| <b>Consultation Response from KC, Highways Development Management (HDM)</b>                   |                                     |                                     |
| <b>2023/91835 Cliff Hollins Lane, East Bierley, BD12 7ET</b>                                  |                                     |                                     |
| <b>Use of land to provide access and landscaping to adjacent approved warehouse building.</b> |                                     |                                     |
| <b>Date Responded:</b> 04/02/25                                                               | <b>Responding Officer:</b> A.Darwin | <b>Responding Ref:</b> HDC 7-12NE/8 |

Project		PLOT B INTERCHANGE 26, OAKENSHAW	
Client		NETWORKSPACE	
Drawing		GENERAL ARRANGEMENT	
Drawn By:	MSF	Date:	18.07.2024
Checked:	GS	Scale:	1:200
Drawing No:	AMA-22892-ENG-01	Paper:	A1
		Rev:	P05

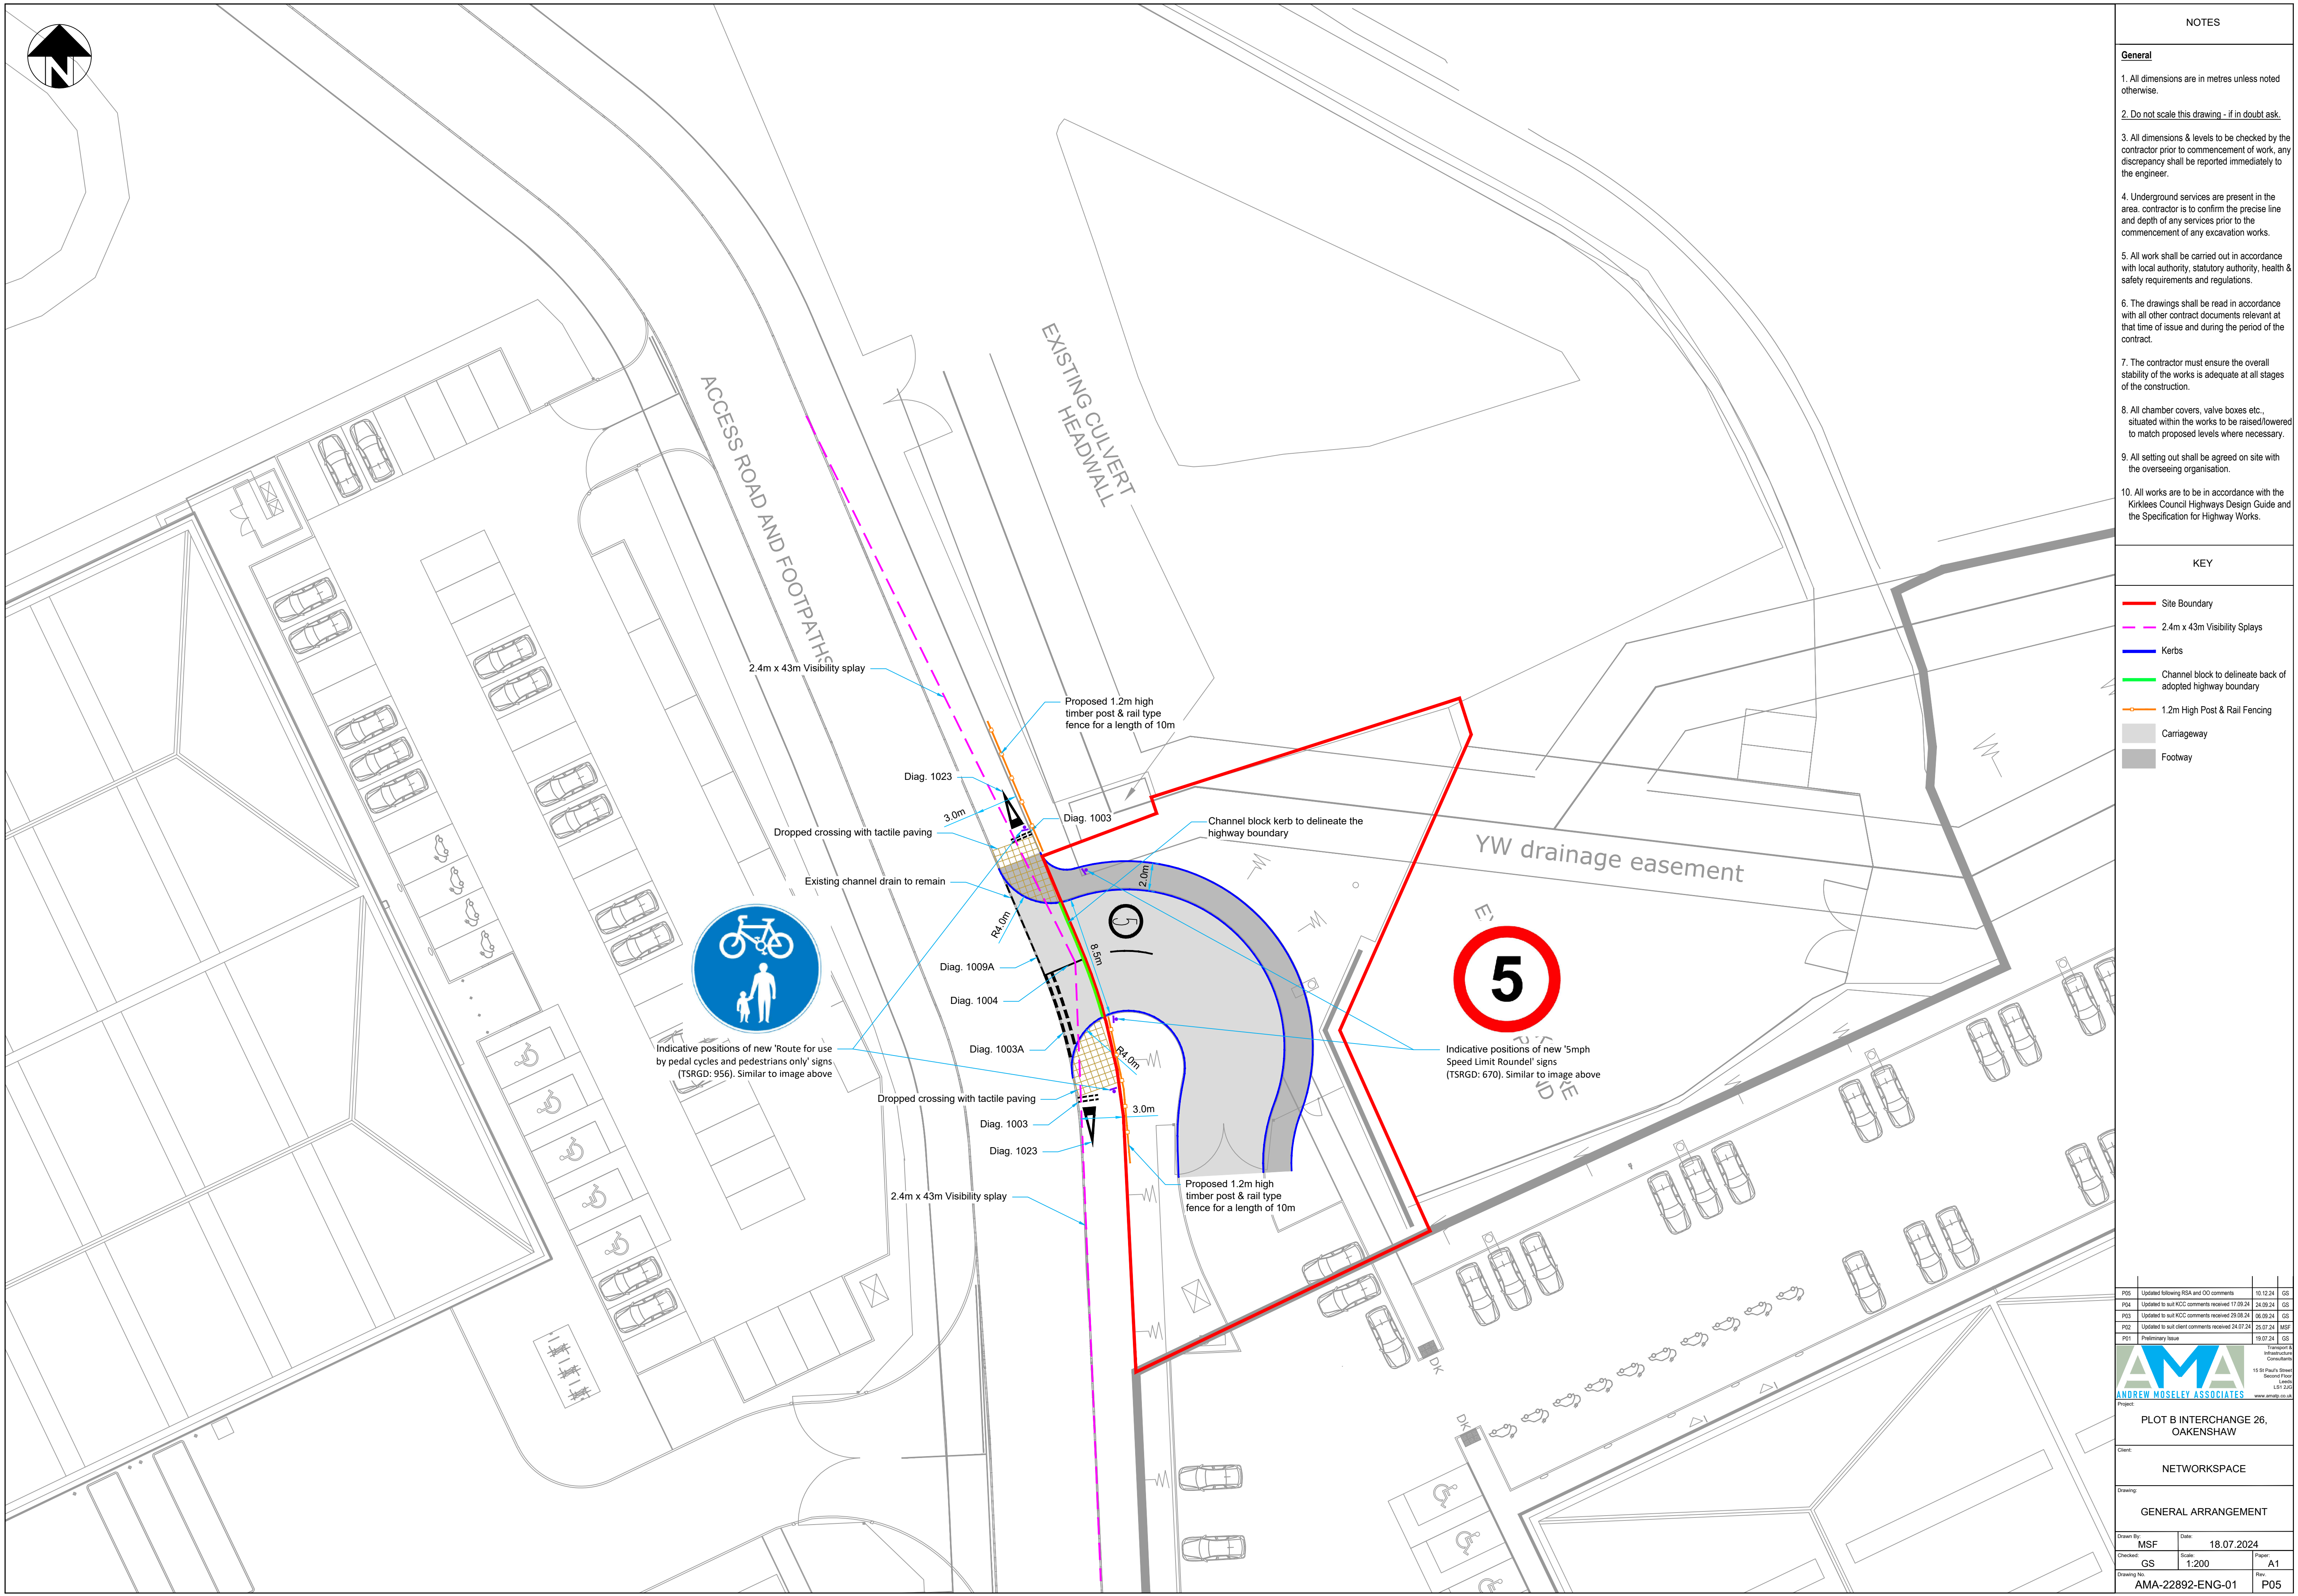
*The car park access shall be in accordance with the preliminary design shown on the approved plan AMA-22892-ENG-01 P06, and shall be fully constructed and made operational prior to first occupation of the development and thereafter retained and maintained for the lifetime of the development.*
